# Rezoning Transportation Analysis

Petition Number: 2020-157

General Location Identifier: Tax ID: 07106117

Date	Description
11-30-20	First Review (EL)
12-28-20	Second Review (EL)

REZONING PETITION
#2020-157

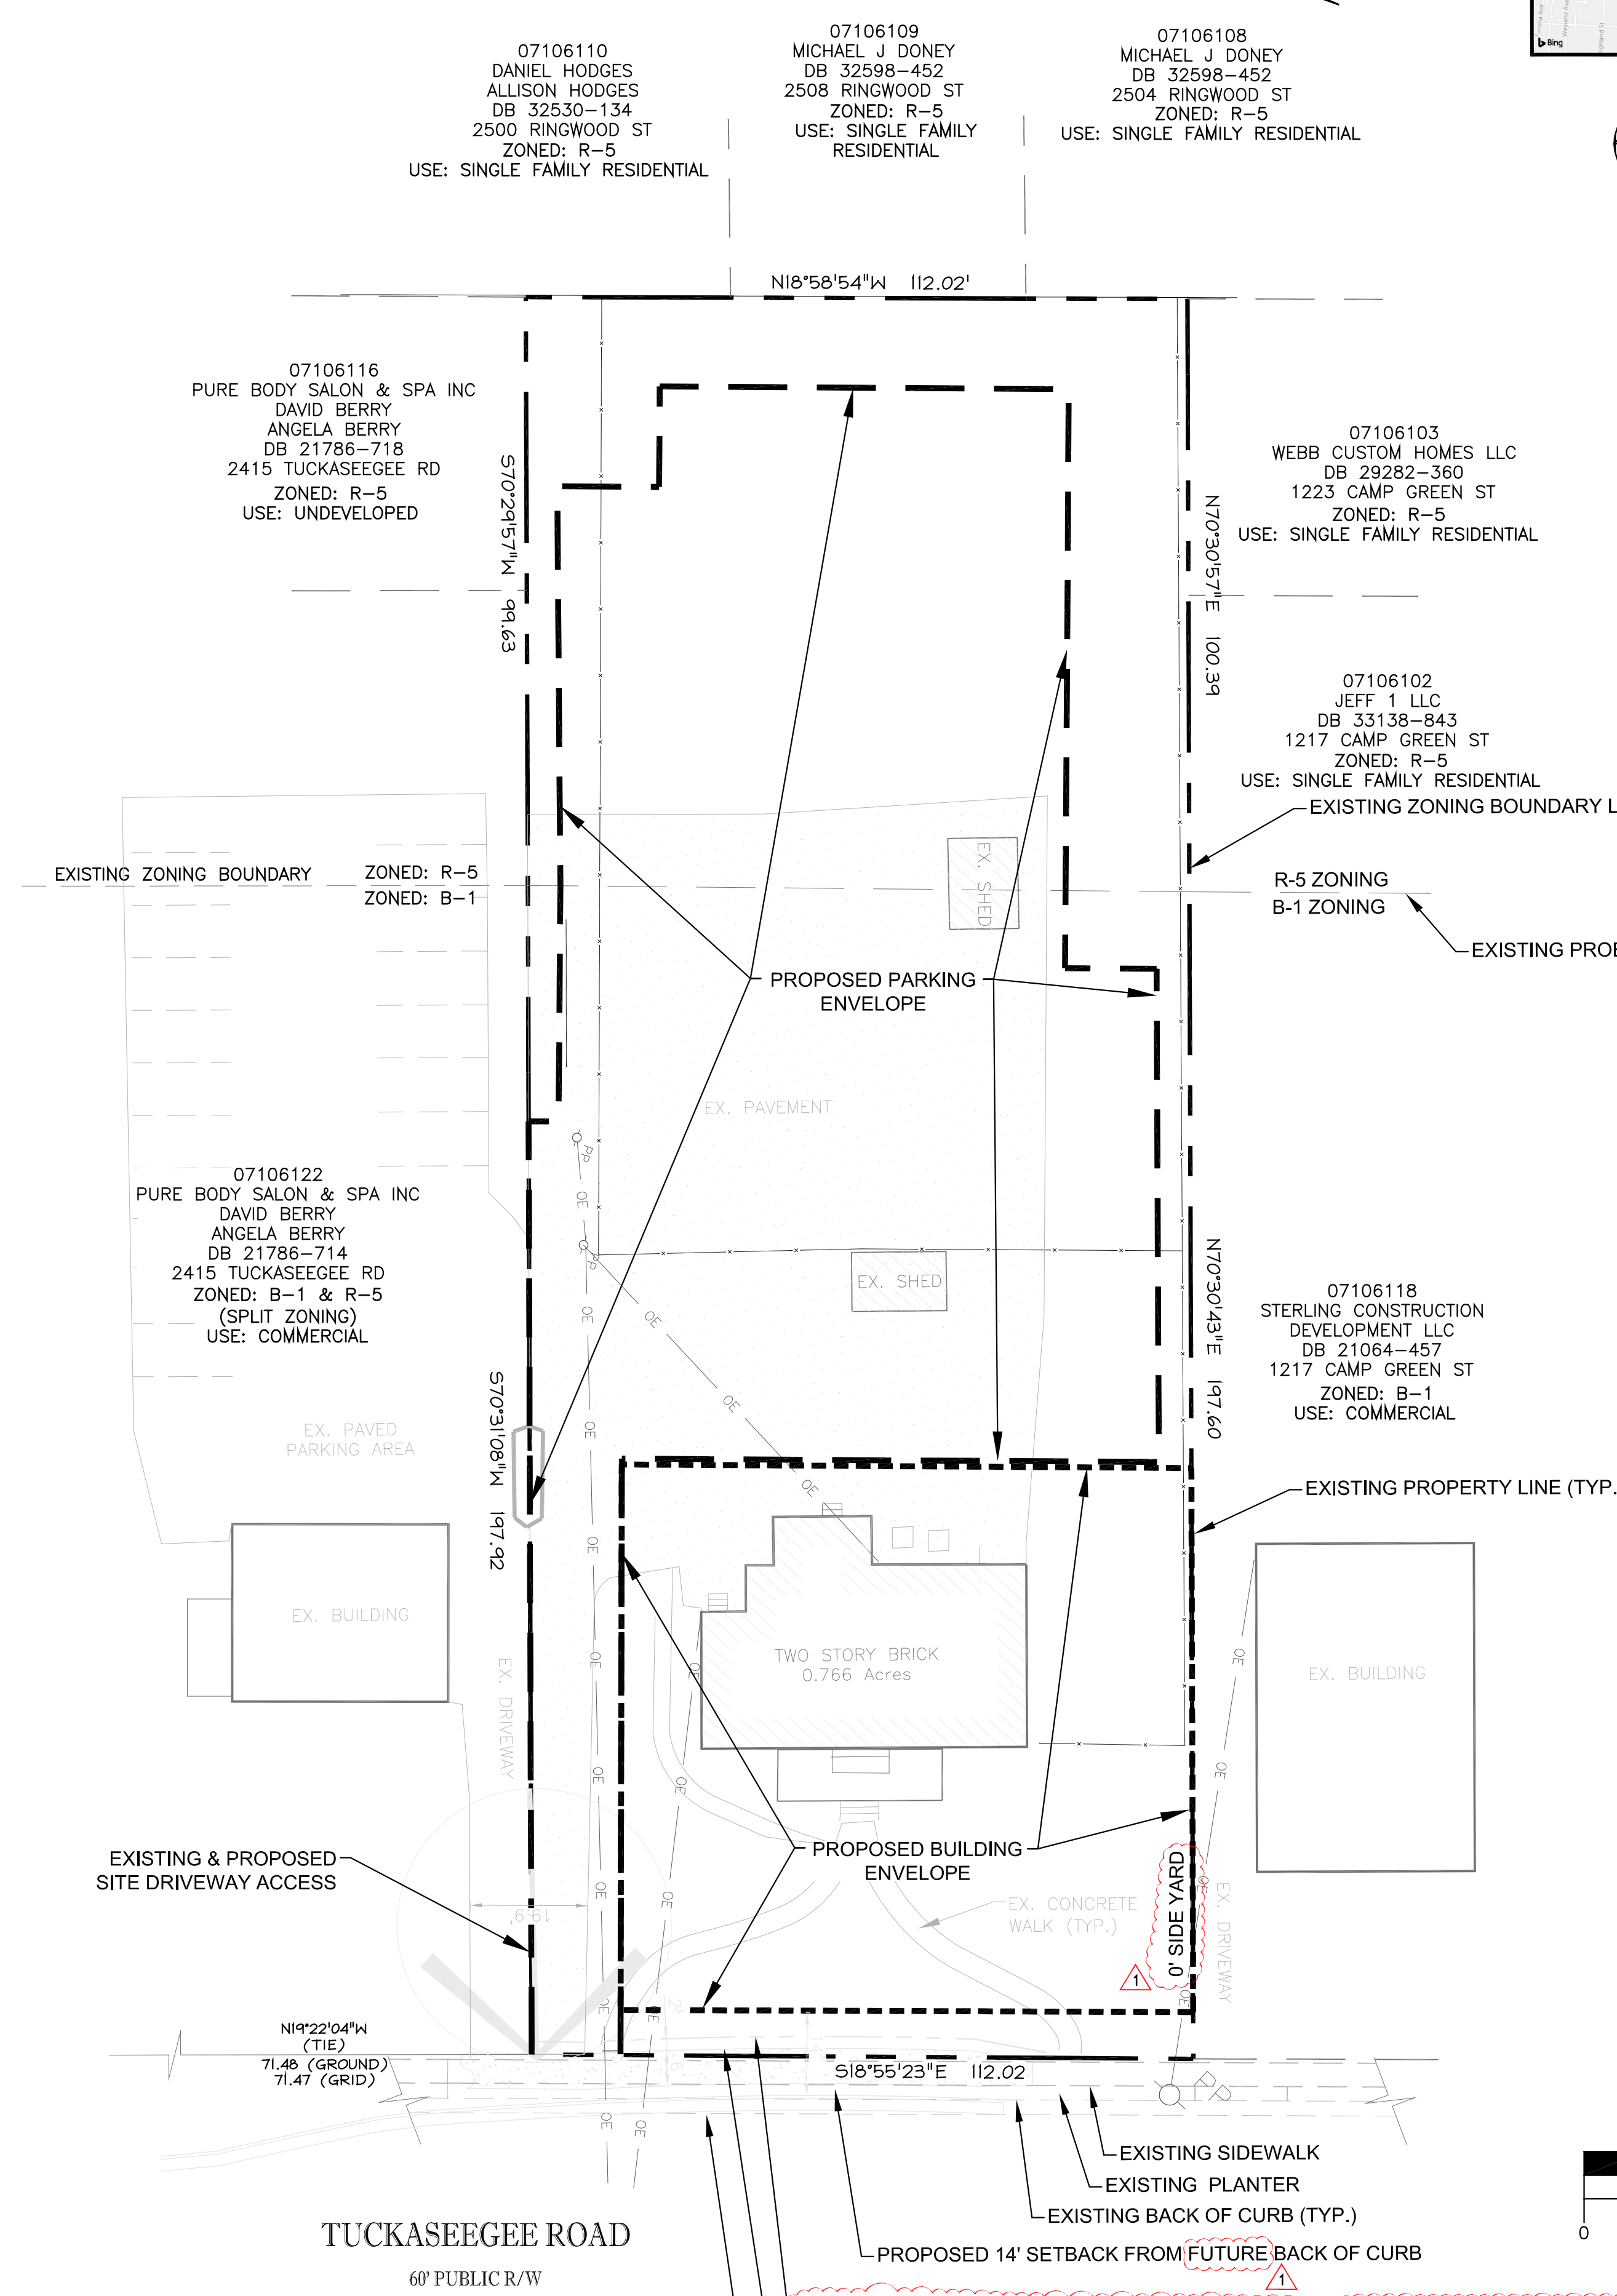
4. **New comment (site plan dated 12.15.2020):** Revisions are needed on the site plan and conditional note (Section 7.B) to relocate the proposed 8-foot planting strip to the Tuckaseegee Road back of curb, separating the proposed 6-foot sidewalk from the roadway, as required within Chapter 19-174 of the City Code, to allow the planting strip to function as necessary.

JOB NO.: 2020-105
DRAWN BY : MDN
DATE : 9.21.20
SCALE: 1"=20'
TECHNICAL DATA SHEET & EXISTING CONDITIONS
RZ.1

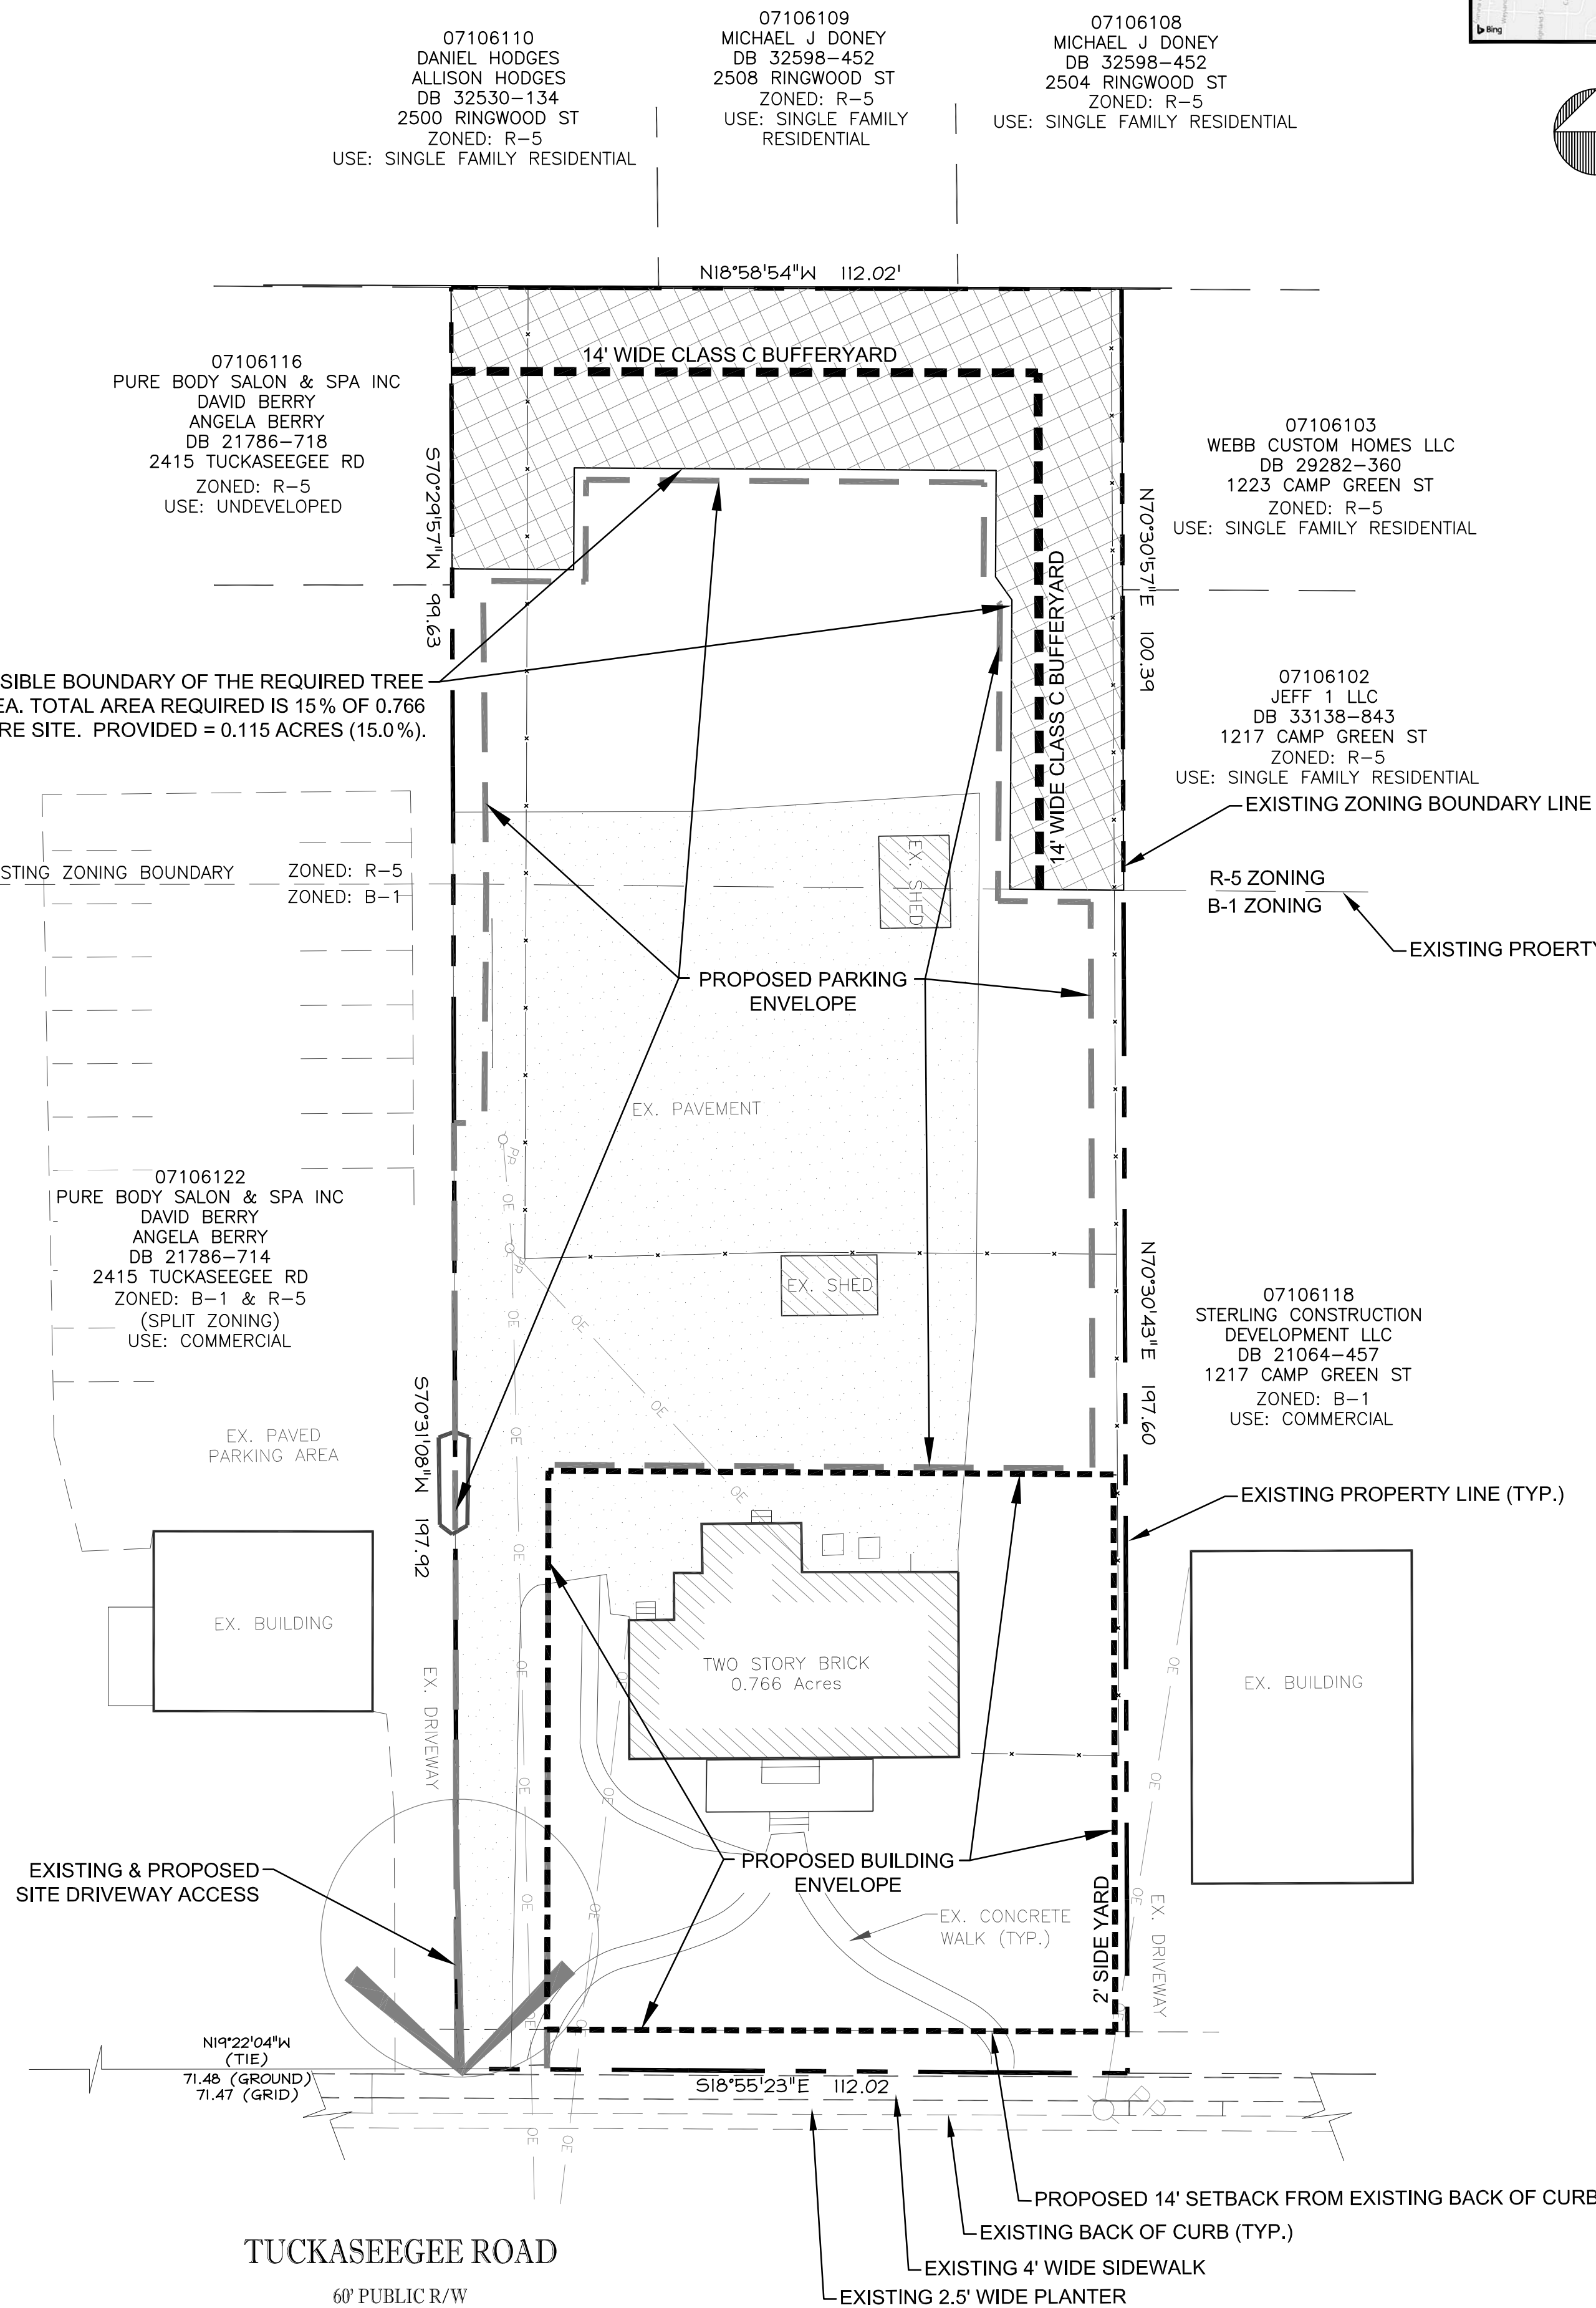
Label and dimension the curb and gutter from the centerline for each road on the site plan.
